KITTITAS COUNTY

MEMORANDUM

TO: All Staff
FROM: Public Works Planning Review Team
DATE: August 20, 2020
SUBJECT: BL-20-00019 Land Lloyd

SHT
2
 OF
2

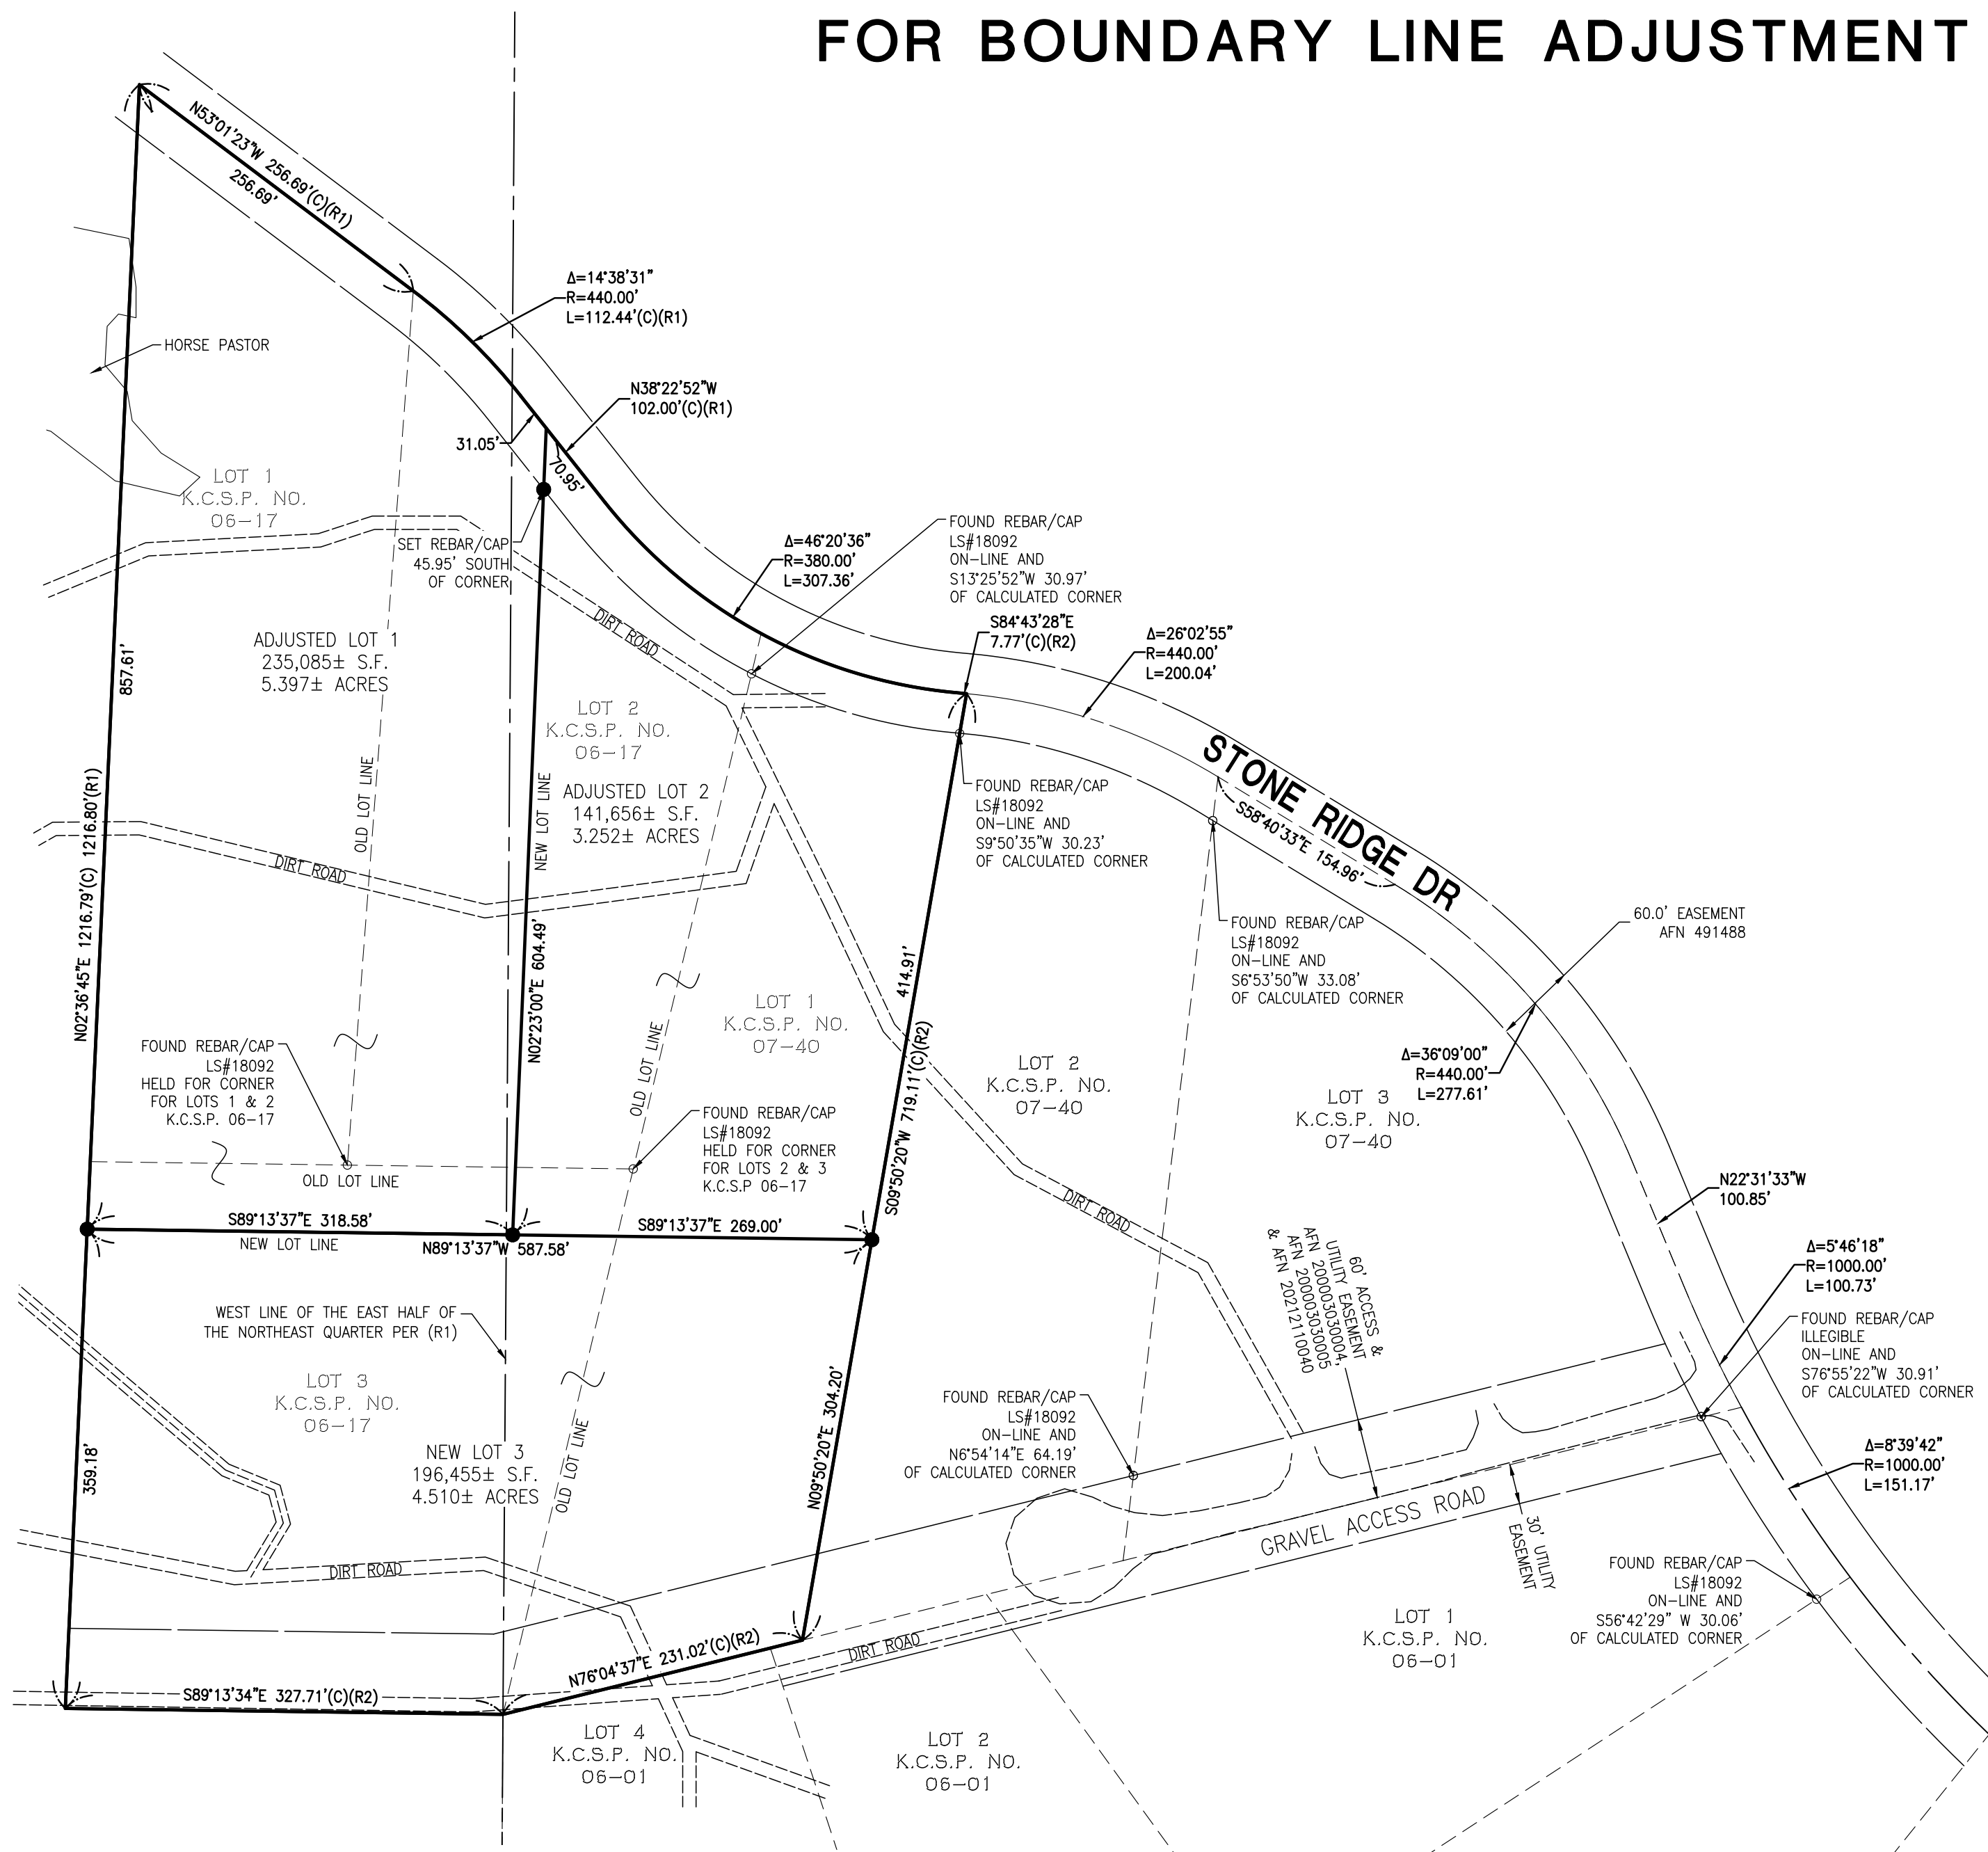
3. As the section corners have not been included, it is assumed that the found property corners were held as controlling ties. If this is the case, the survey map will need to show ties to all the corners utilized to determine the boundaries.

4. Include a definition of the '(C)' notation in the legend.
5. There is a North South line that is not described or dimensioned to that falls near the East boundary of Lot 1. Please describe or remove.

6. Please include the offset distance to the corner set as a witness to the NE corner of Lot 1.
7. Please include the following notation for Stone Ridge Drive. "Private paved road in 60' easement"

8. The Auditors Certificate is required for each page.
9. There appears to be a sizable portion of Lot 1 being utilized by the neighbor to the East. Please note and show this usage line.
